OUT19/10163

**Atlas-Campaspe Mineral Sands – MOD 1 – Optimisation of mining and rail loading
(SSD-5012- Mod-1) (Balranald Shire)
Environmental Assessment**

Liz Rogers
Manager, Assessments
DPIE Water – Strategic Relations
6 September 2019

TRONOX
 OPTIMISATION MODIFICATION
 Ivanhoe Rail Facility Bore Census Results

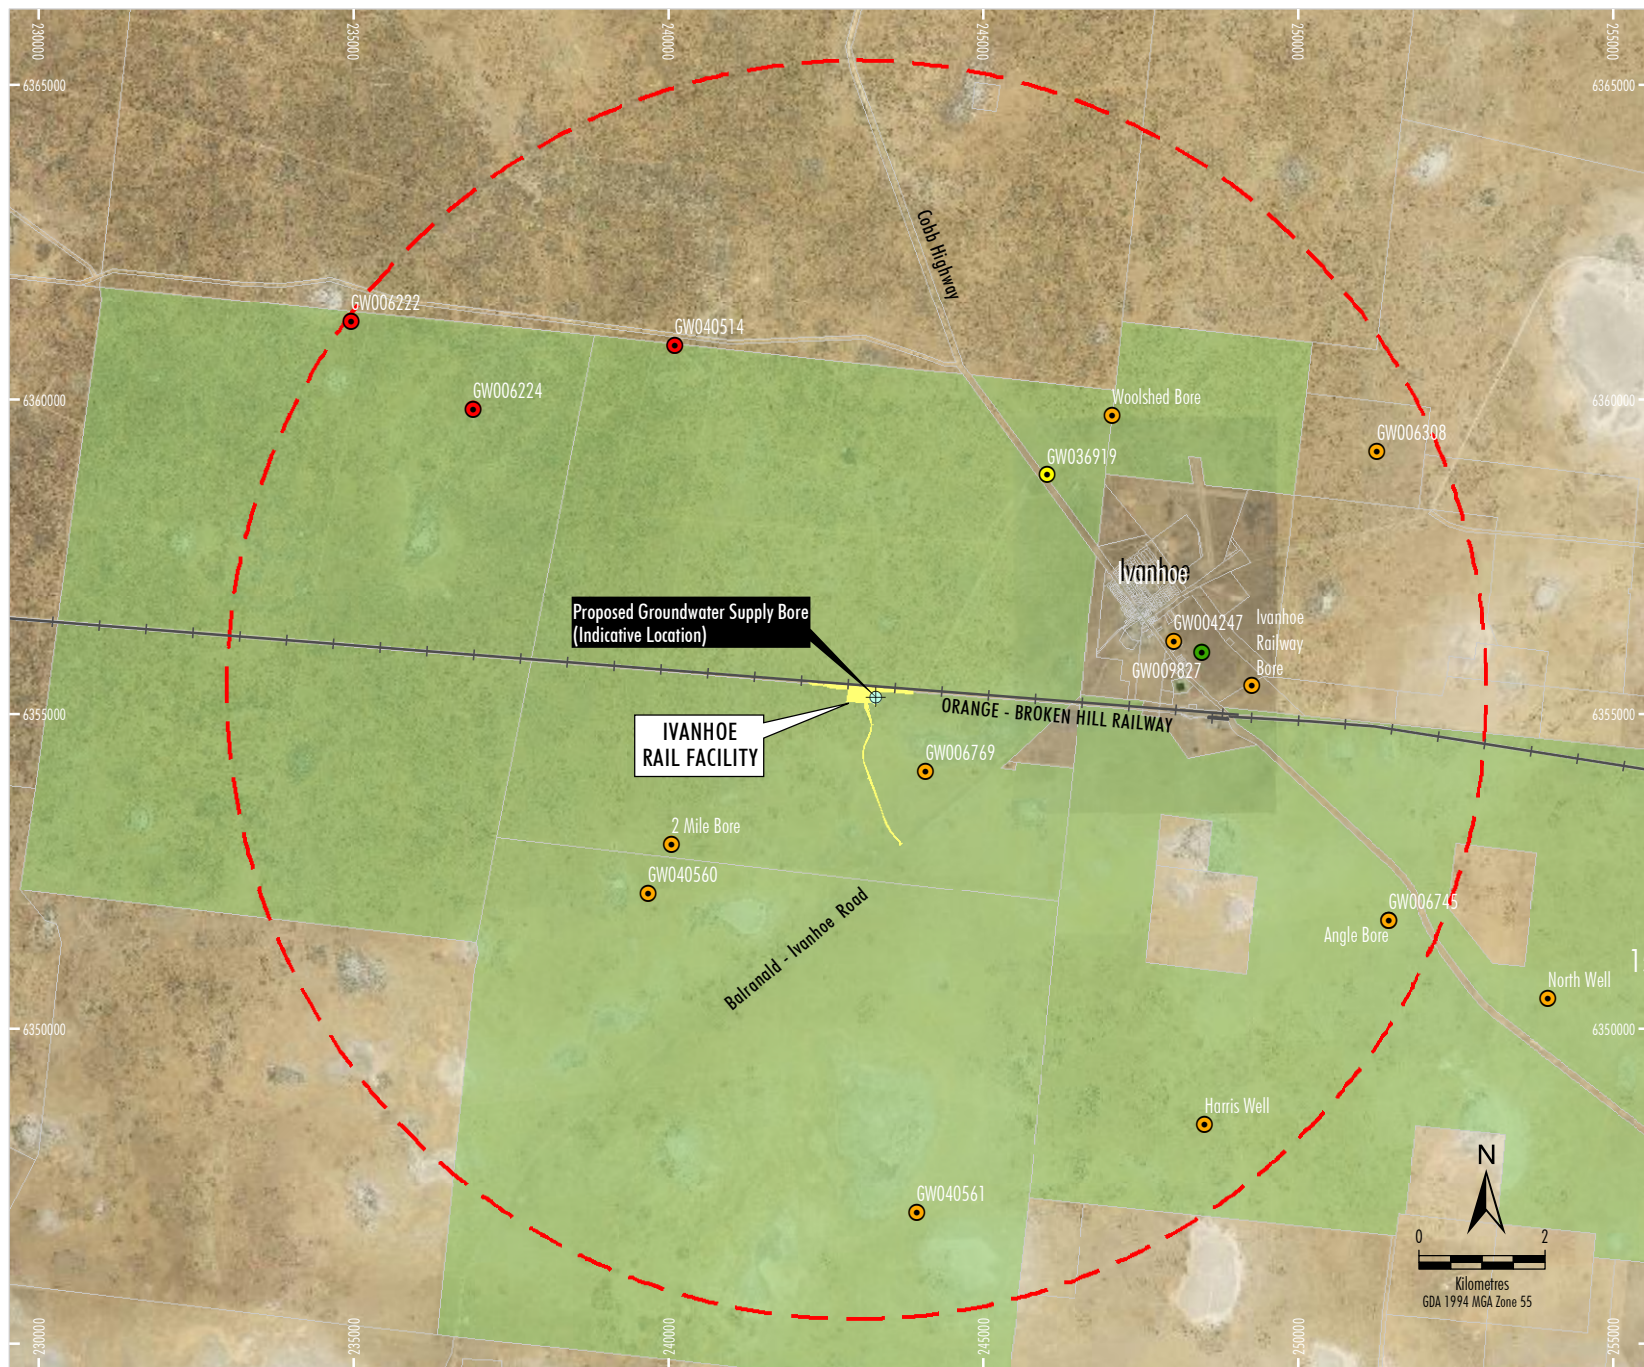
- The revised groundwater monitoring plan should include either monitoring for levels or quality at the nearest adjacent bores GW006769 and GW040560. Alternatively, if access is not available at GW006769/GW040560 a monitoring bore should be installed immediately south (minimum of 100 m) of the proposed water supply bore. This monitoring bore should be monitored for groundwater level and quality (Electrical Conductivity, pH, standard anions and cations, and metals) at the same frequency proposed for the water supply bore.
